CITY OF ALBUQUERQUE

**Re: ABQ School of Excellence
13201 Lomas Blvd NE, 87112
30-Day Temporary Certificate of Occupancy
Transportation Development Final Inspection
Engineer's/Architect's Stamp dated 7-22-20 (AA) (J22D050)
Certification dated 9-3-20**

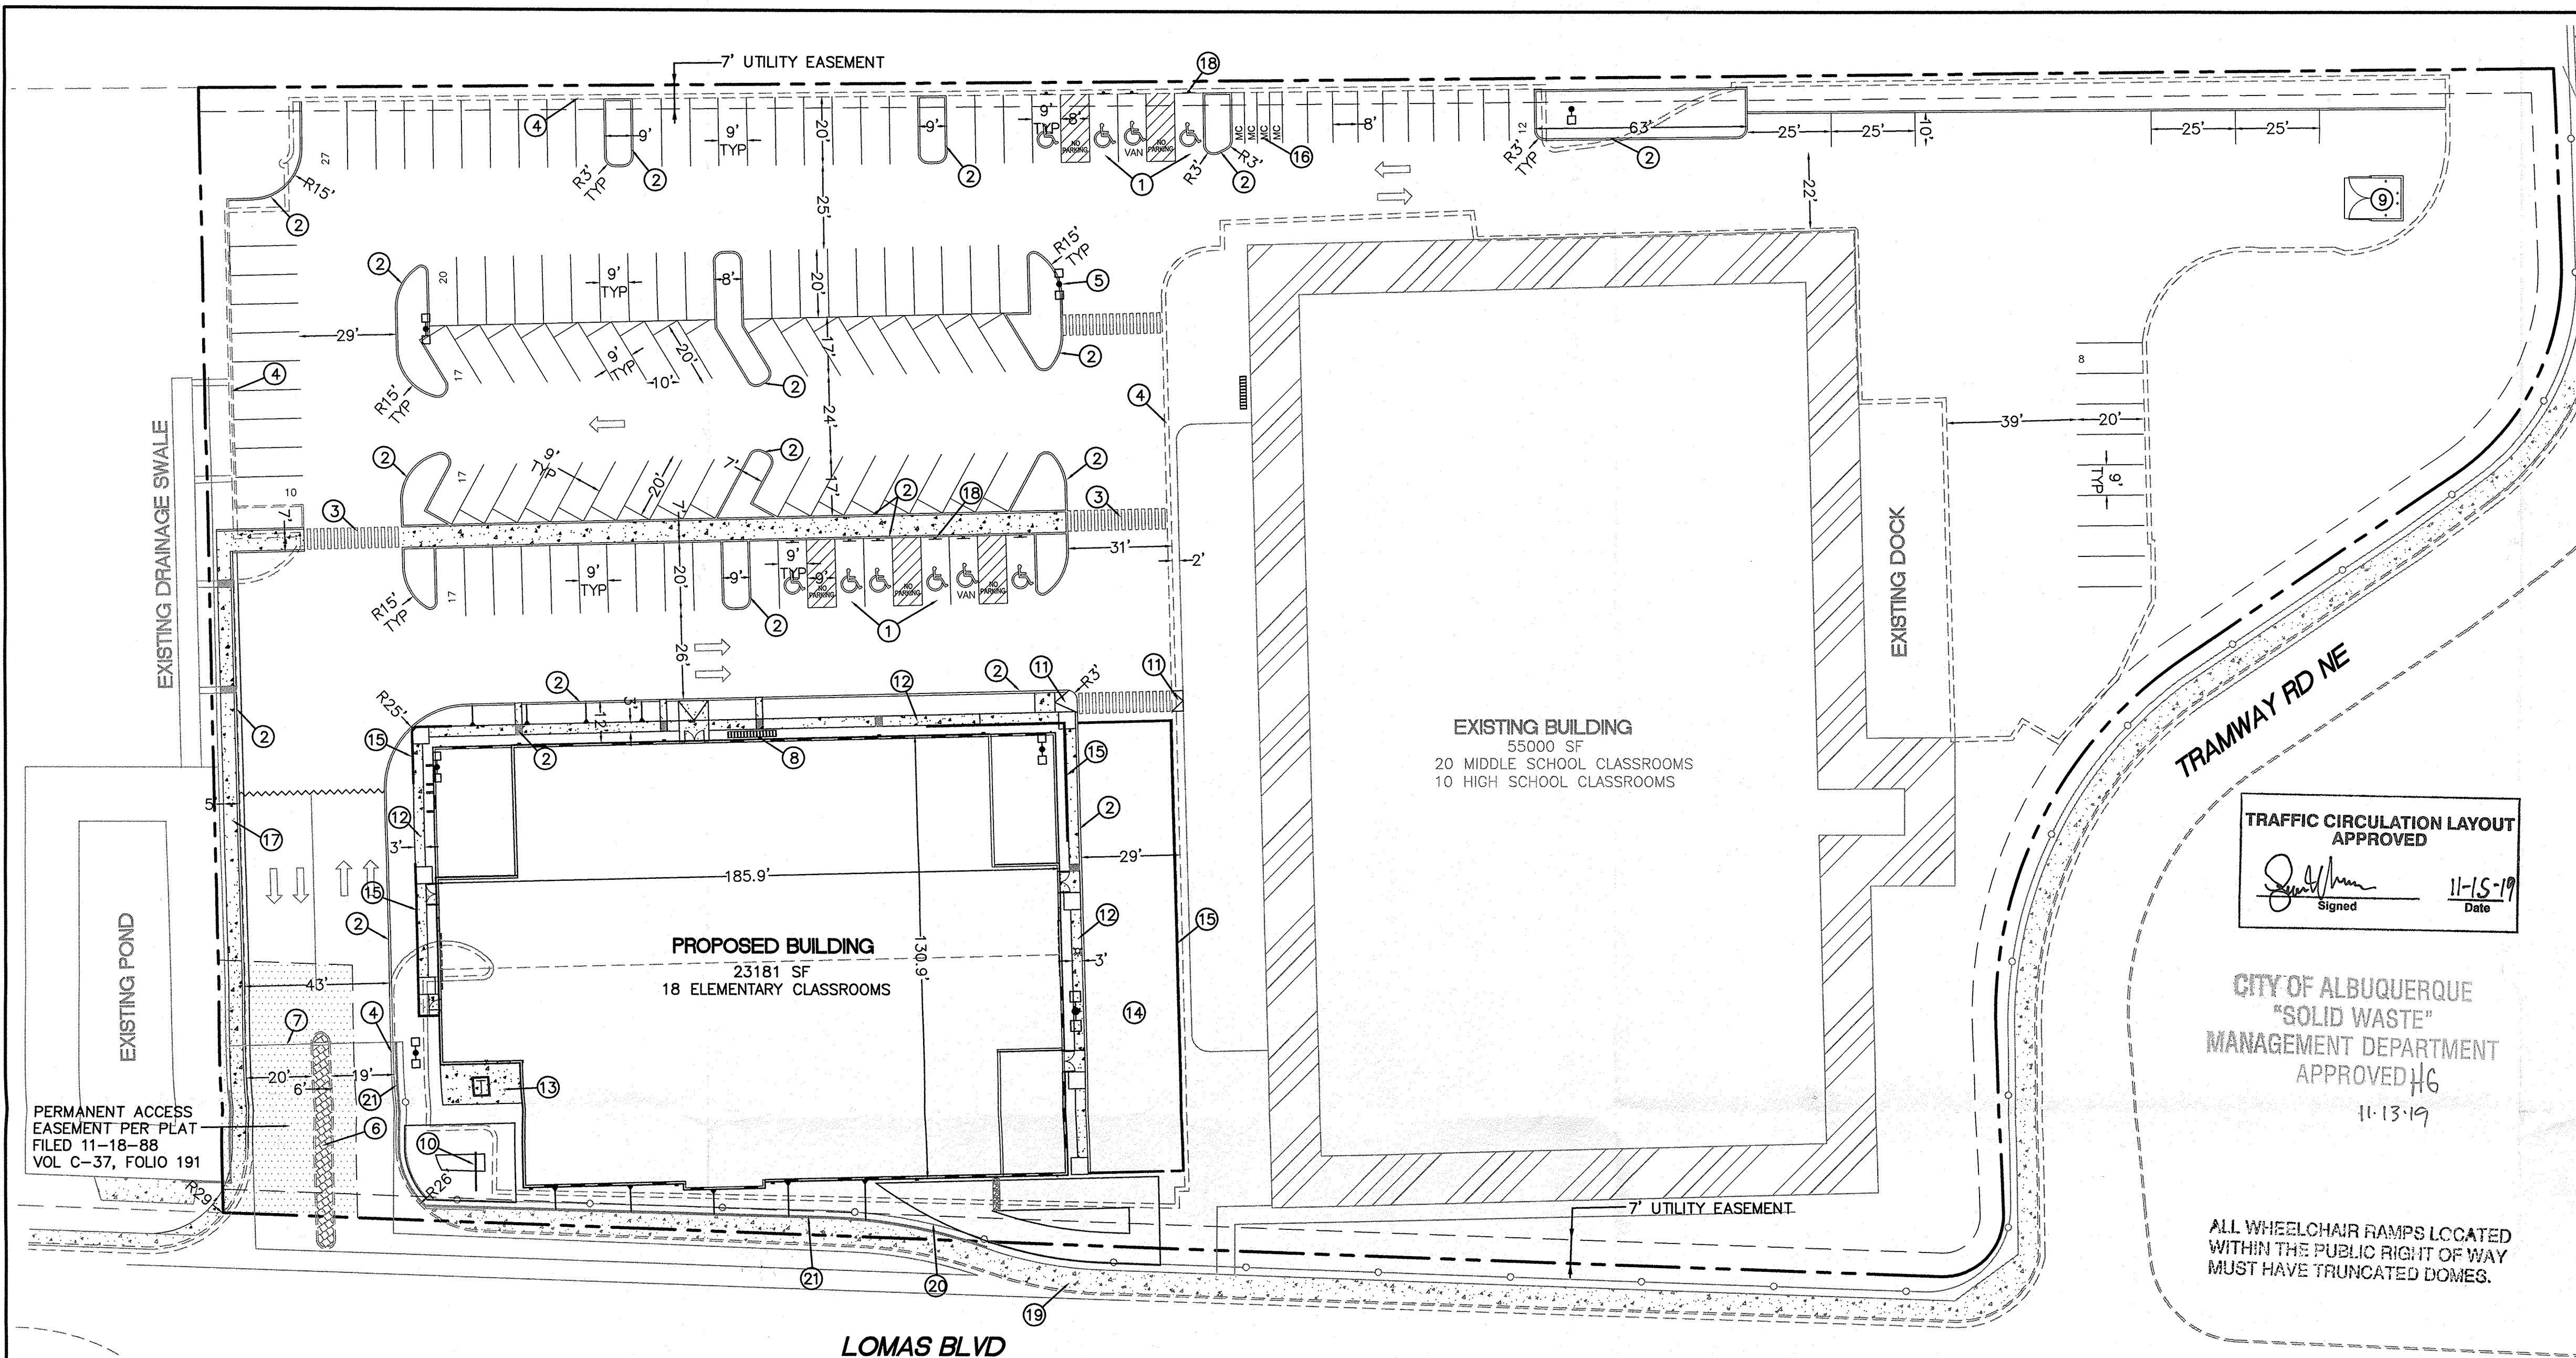
- Please add truncated domes to wheelchair ramps in public right of way.
- Add top plates to sidewalk culverts.
- Complete asphalt floor markings.
- Add motorcycle stalls and signs.
- Add ADA signs to the ADA parking stalls.
- Complete concrete ADA walk path from public sidewalk to building entrance.
- Complete curb & gutter as shown on approved administrative amendment.
